The Planning Inspectorate

Our ref: XA/2025/100270/03-L01

Your ref: EN010152

Deadline 2 – Environment Agency responses to The Examining Authority's first written questions (ExQ1).

Photovoltaic Development Partners GmbH
Kurfürstendamm 52
10707 Berlin, Germany

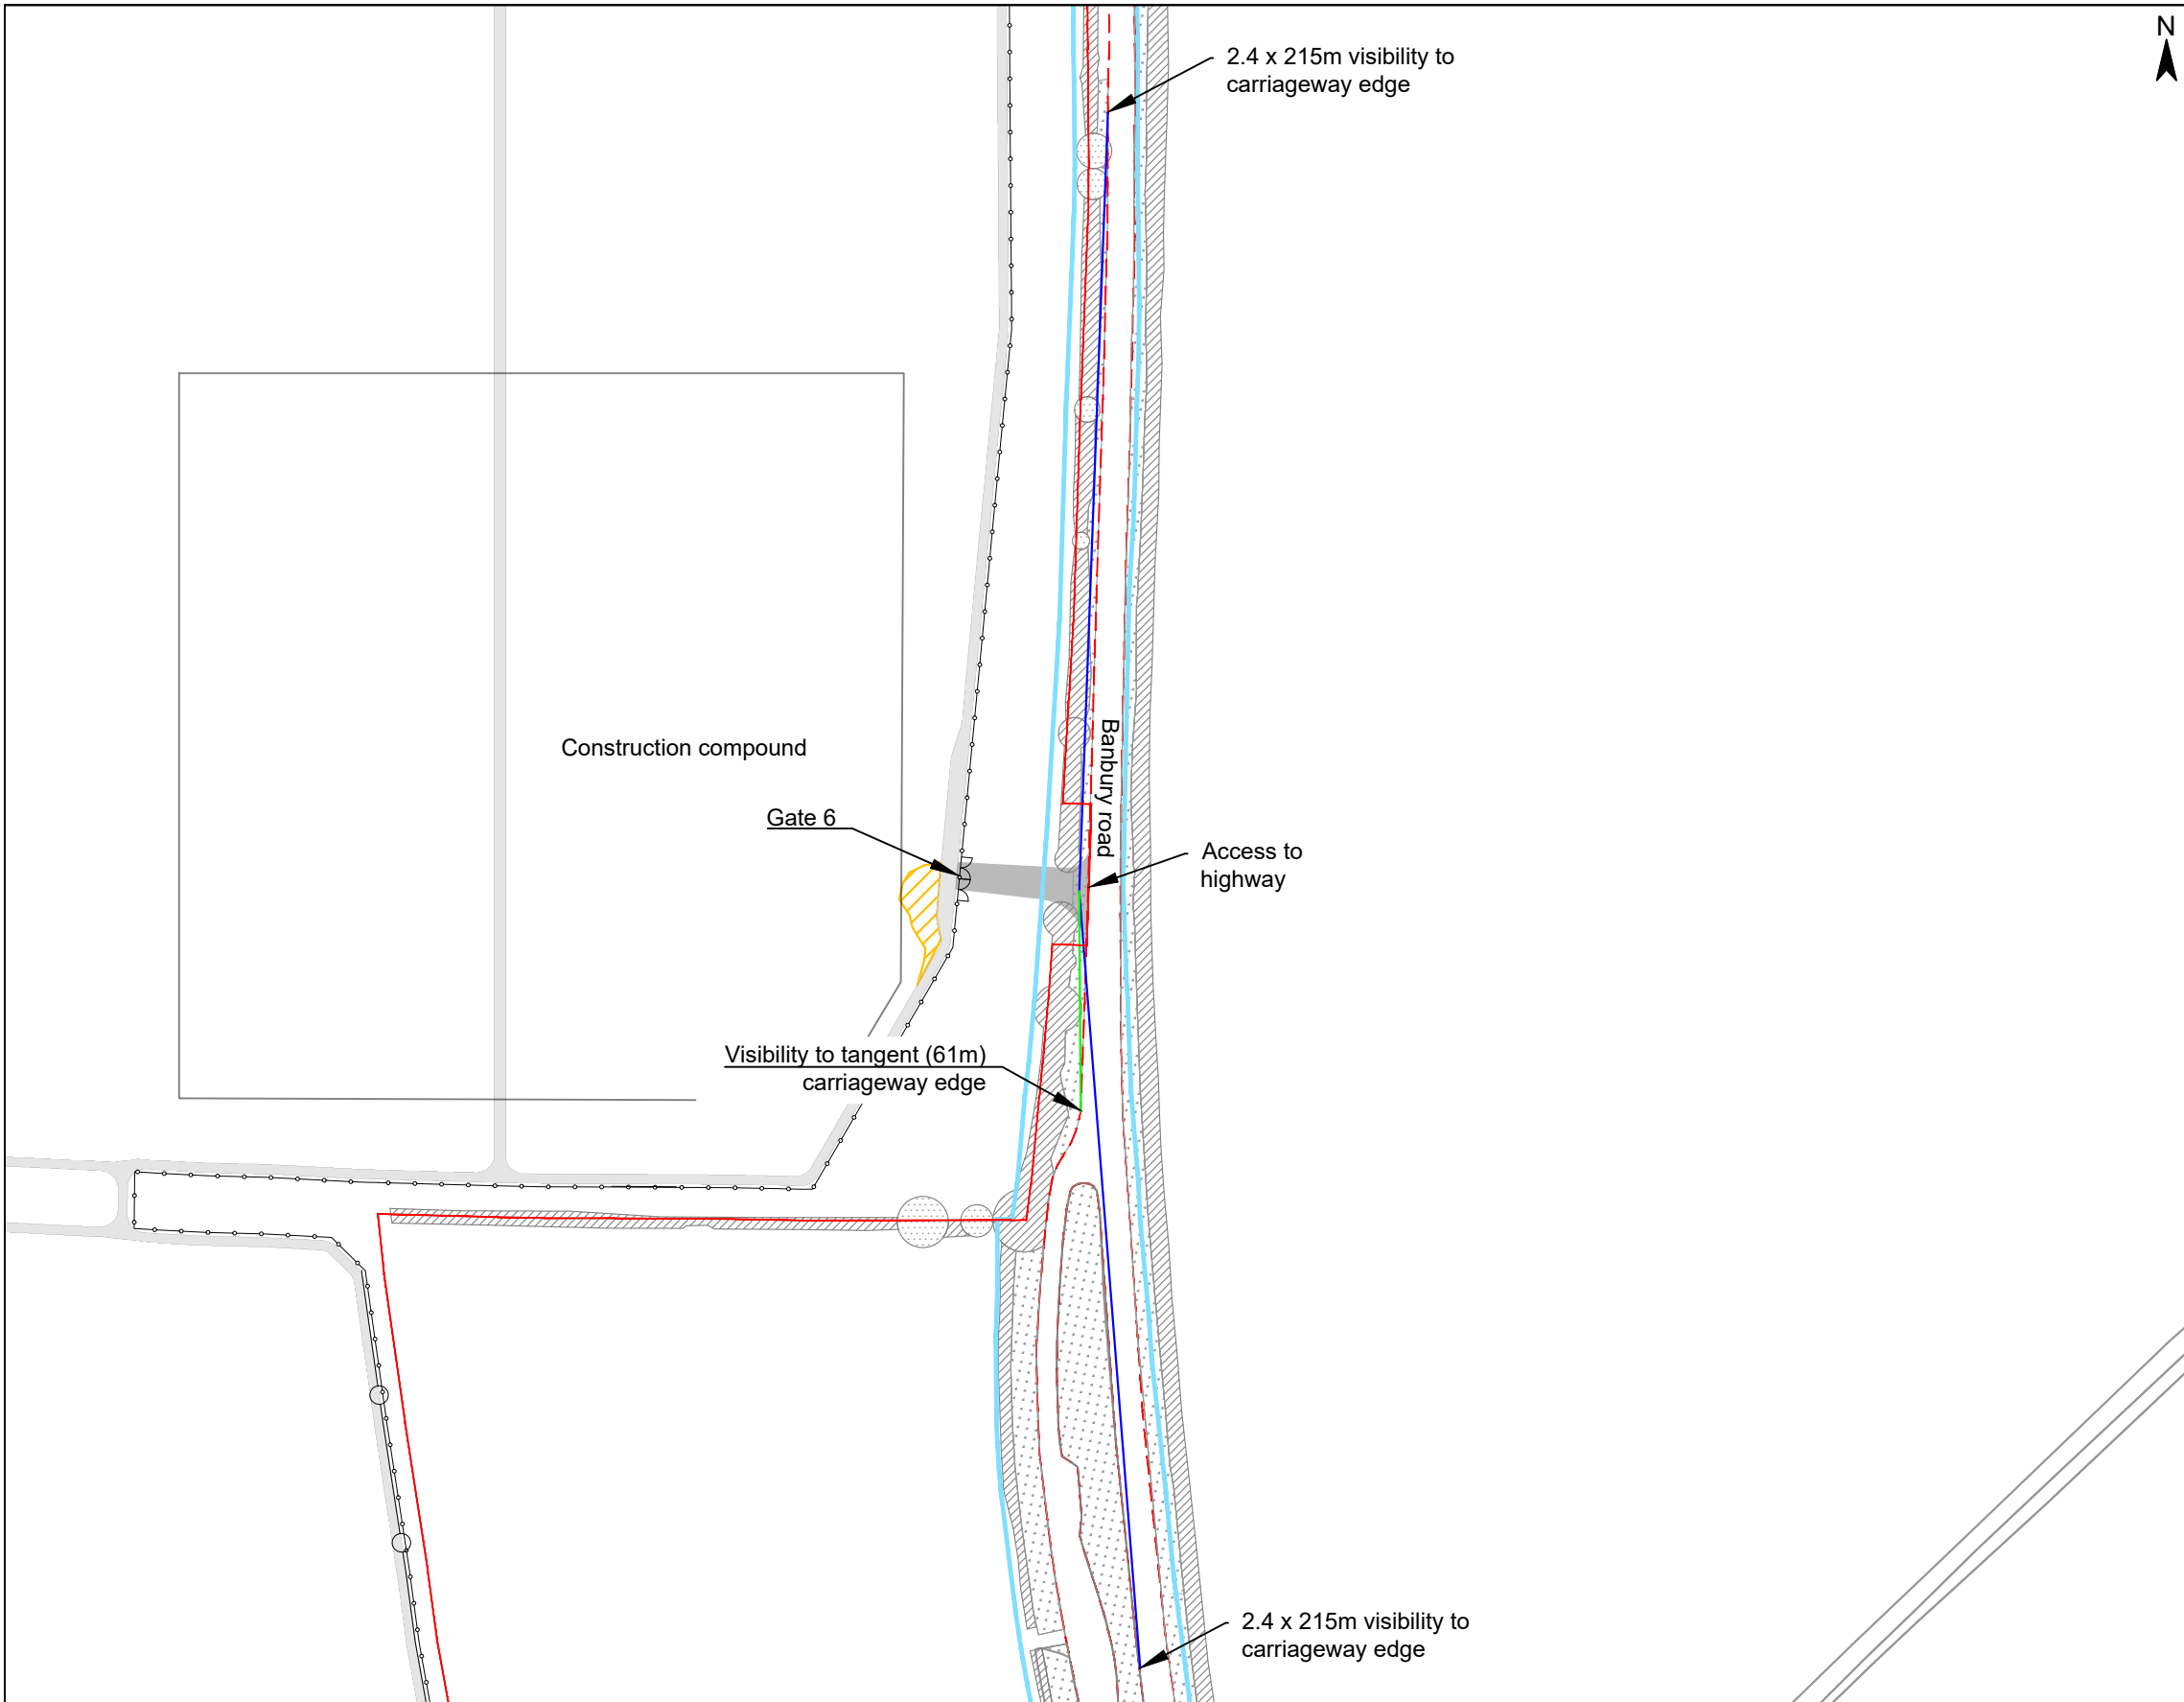
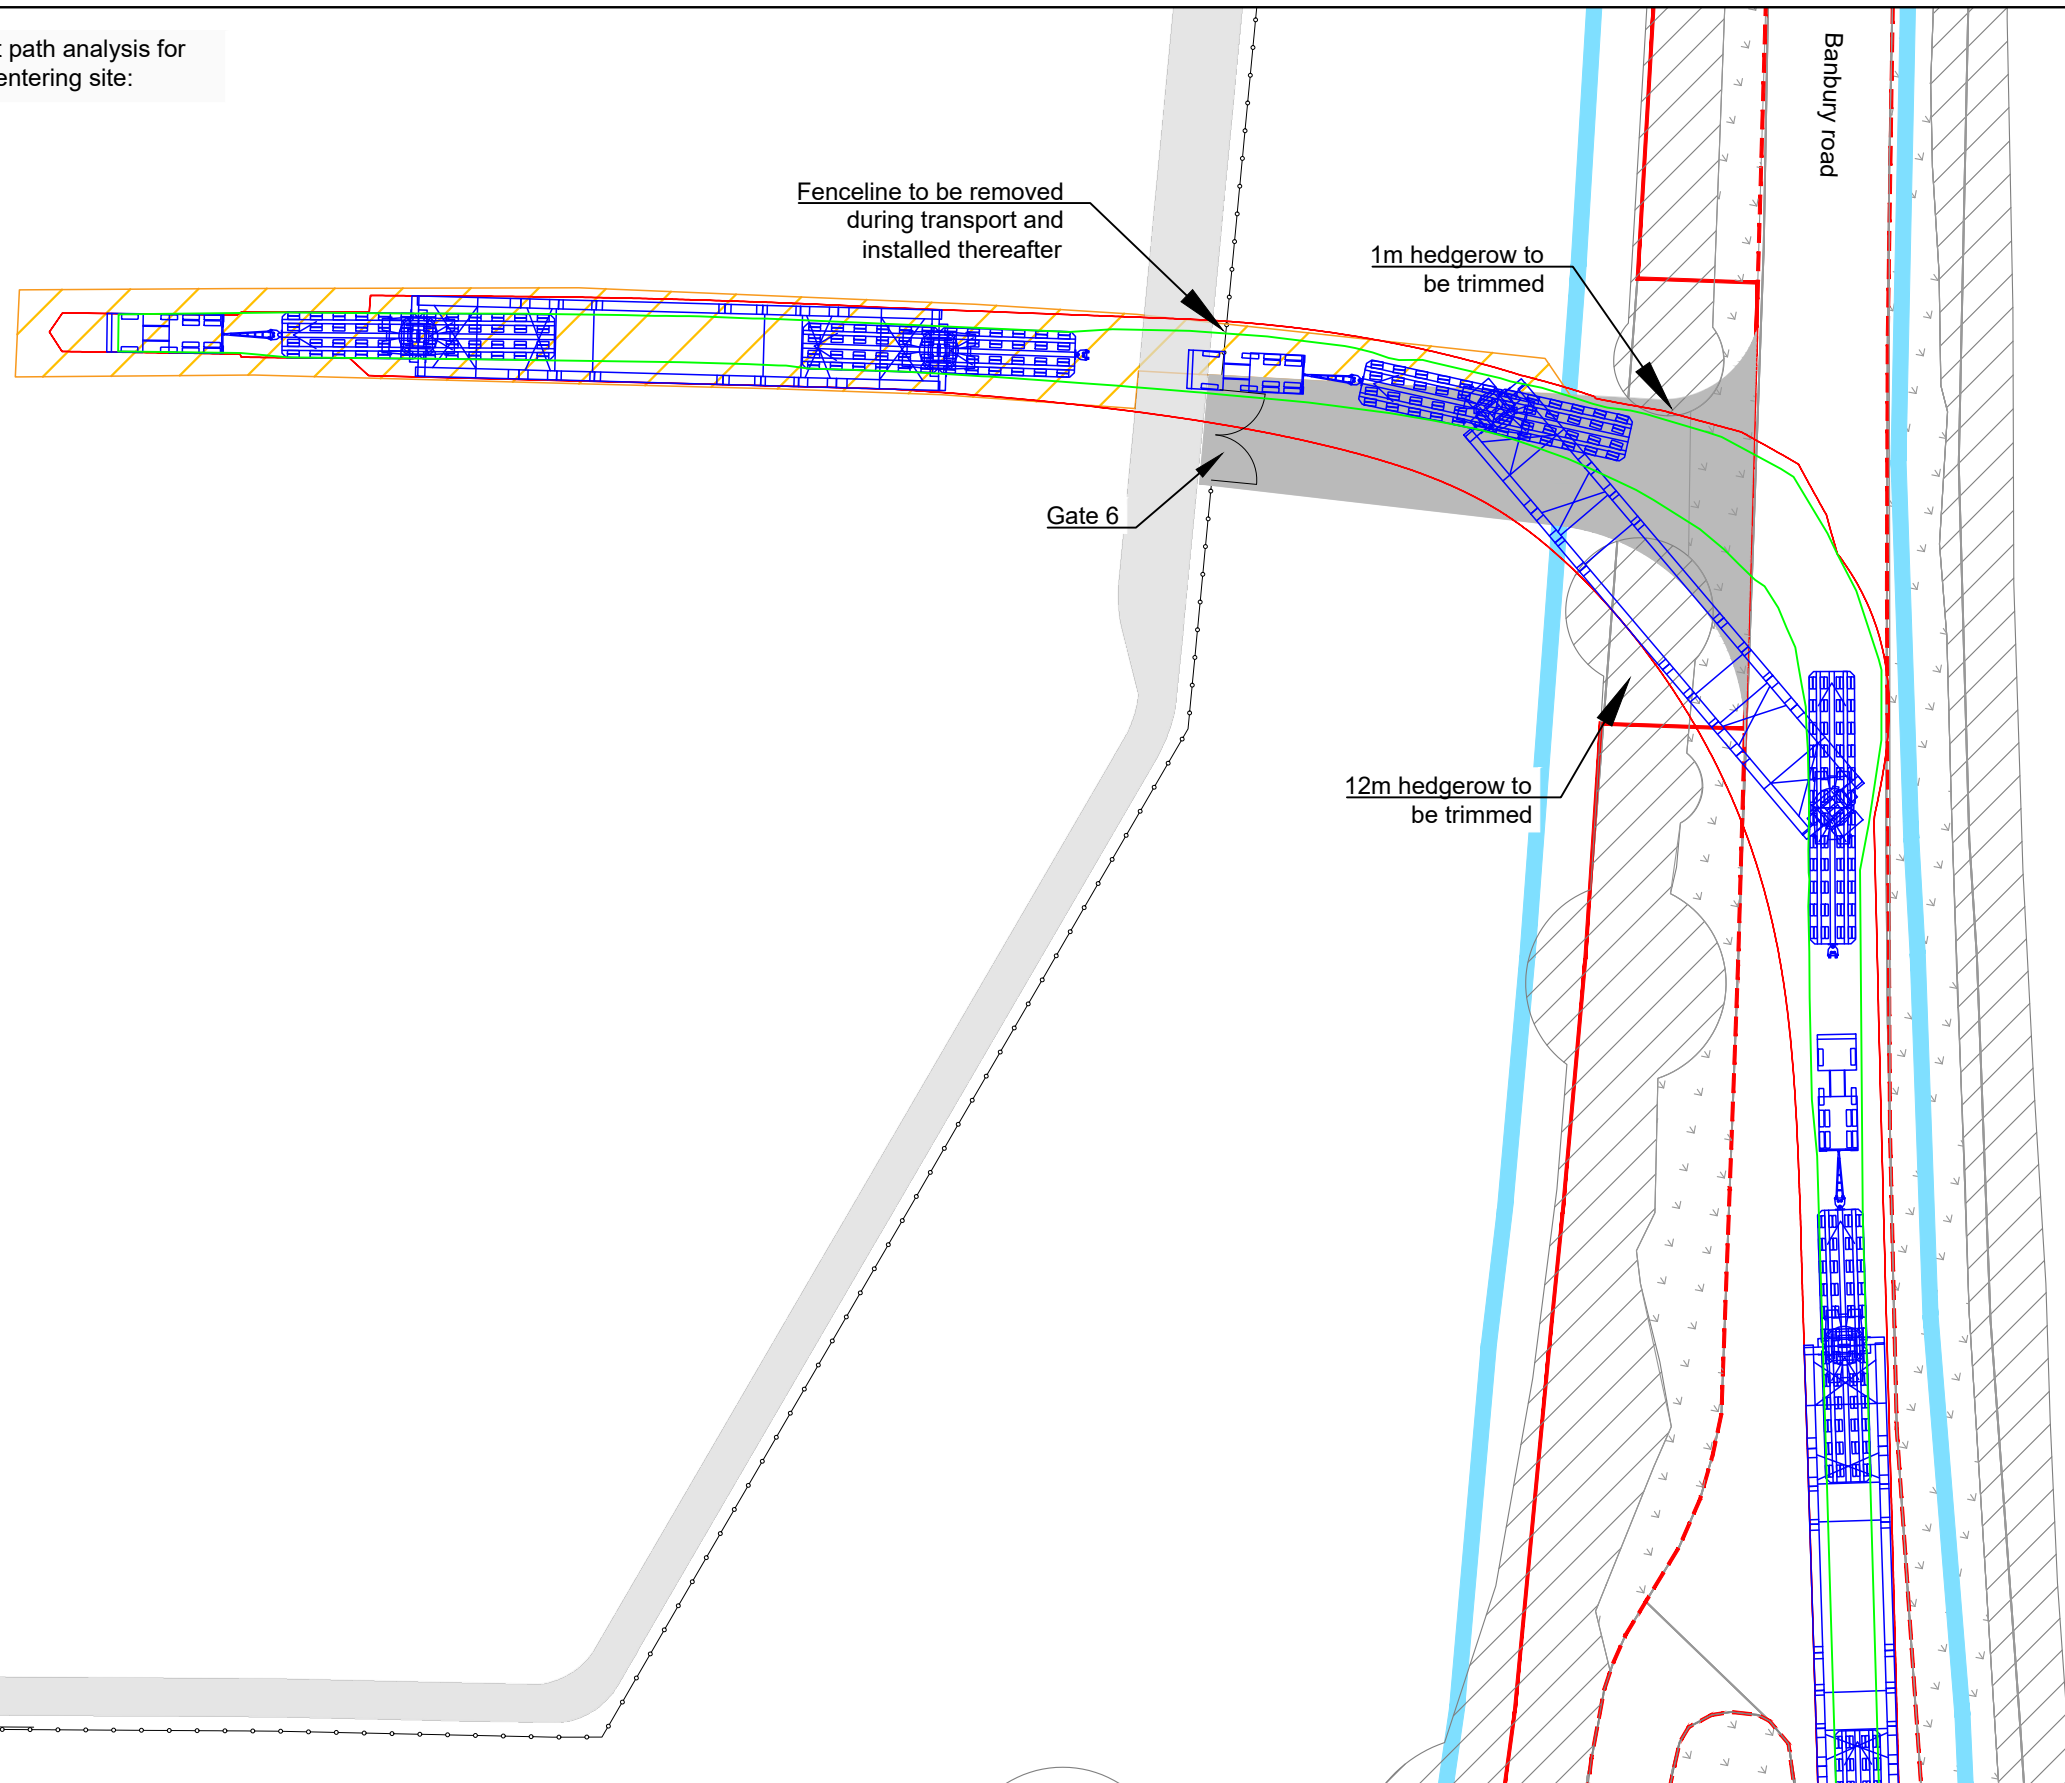
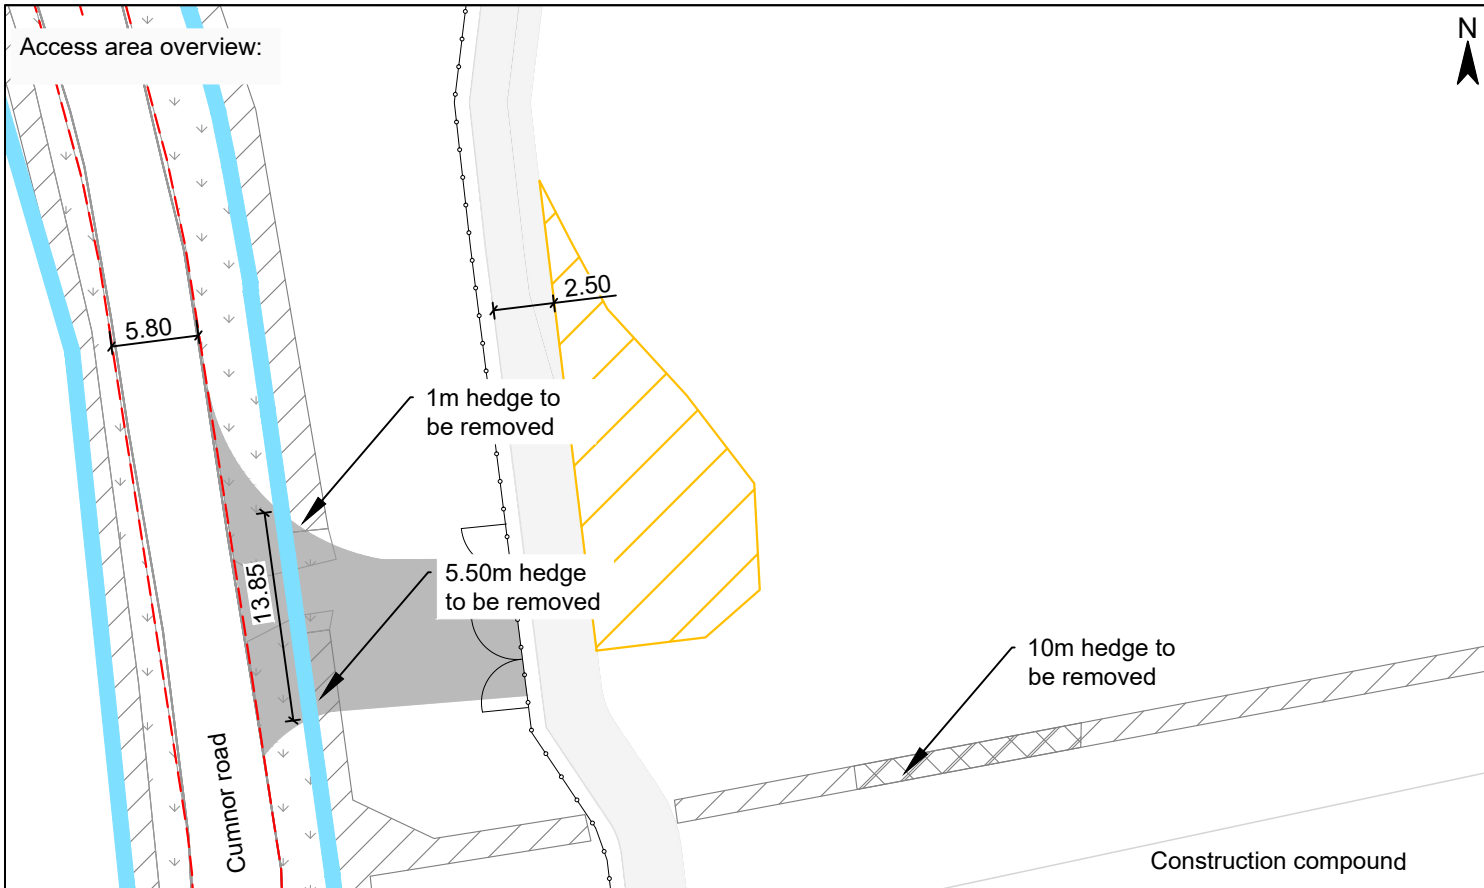
Clarify if hard surfaces and maintenance are existing or new, and whether the Applicant will manage any runoff.

Proposed embankment works should not inhibit flood flow routes. May require CFS if within the design flood extent.
